Please upload the amended drainage plans attached to this email onto Ocella for **LU/90/20/DOC** for Parcels A2 and B6 at Hampton Park.

Comments;

Paul Cann
Principal Engineer (Drainage)

Flow Control Chamber HB1

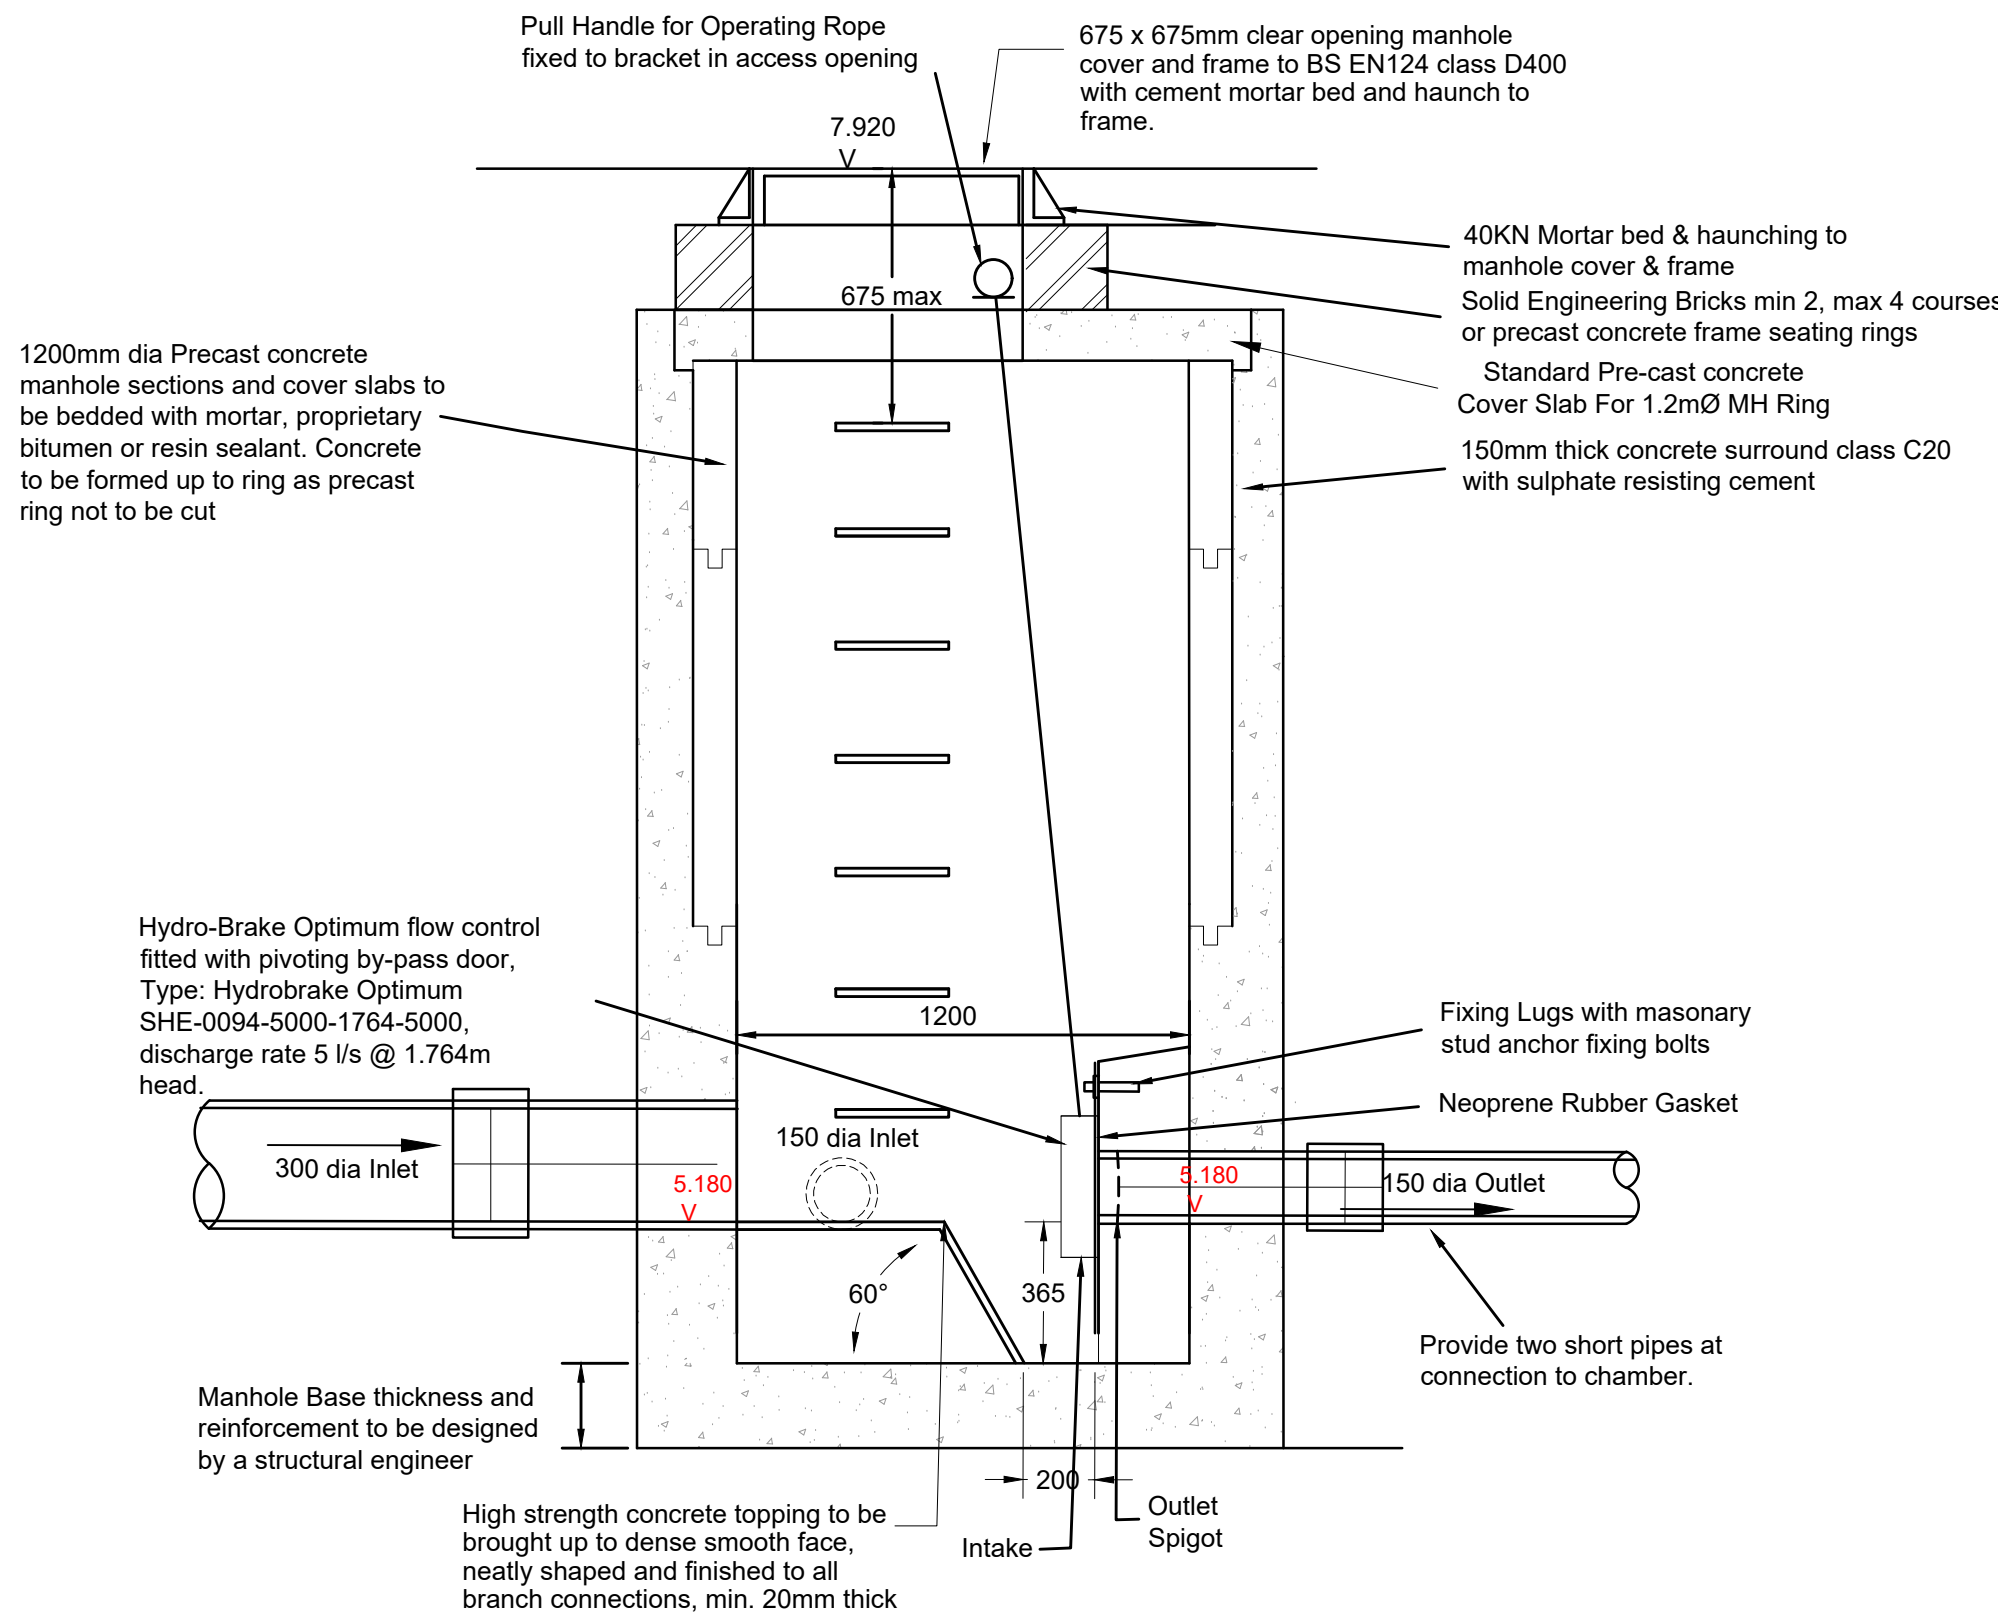
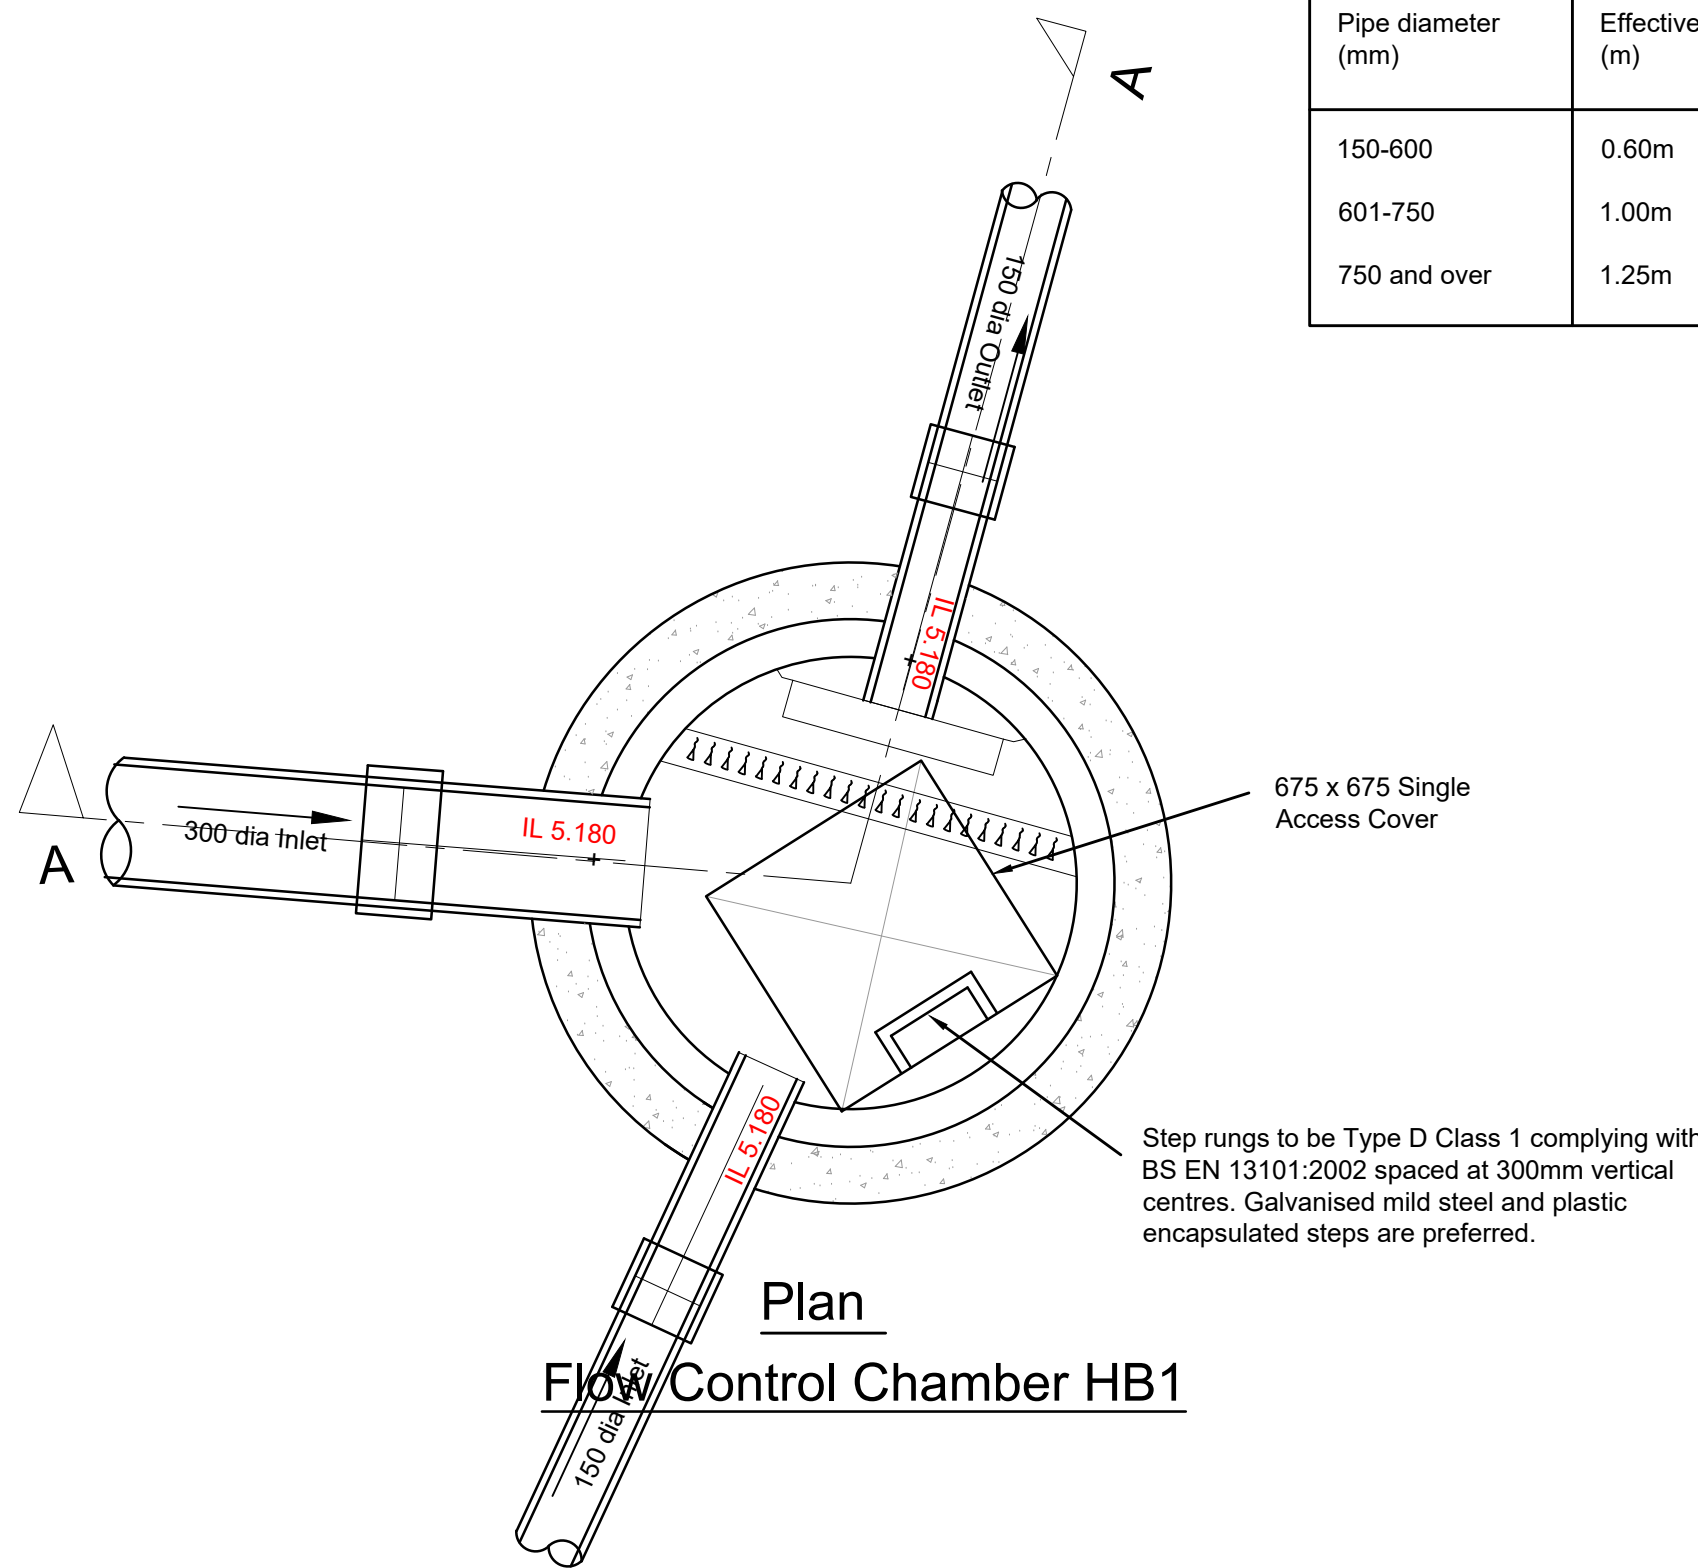
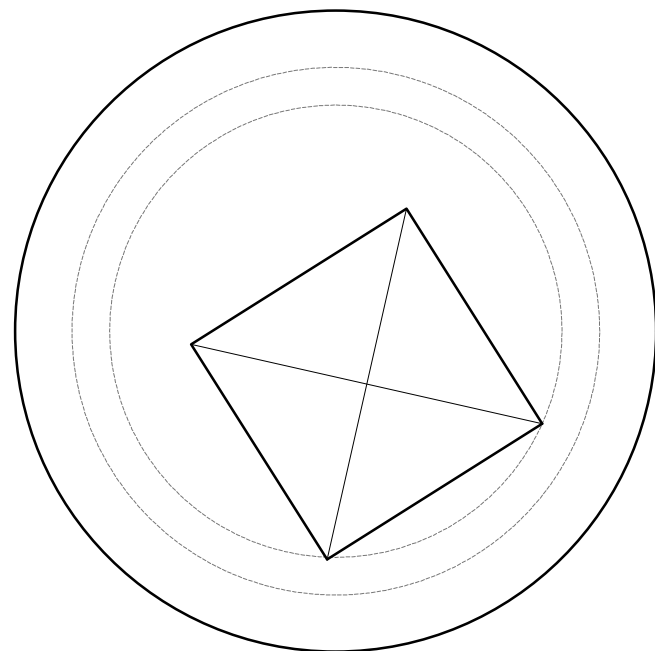
3. Provide channel drain construction details/spec.
4. Hydrobrake chamber HB01 construction detail – connect incoming 150mm connection from permeable paving at soffit to soffit level with 300mm pipe inlet.

6. Both hydrobrake chambers – show base thickness/reinforcement details.
7. Existing manhole SW03A – just upstream of SWA2_01 – what is its purpose? Invert level is lower than the downstream manhole. Please clarify if it is required and adjust as necessary.
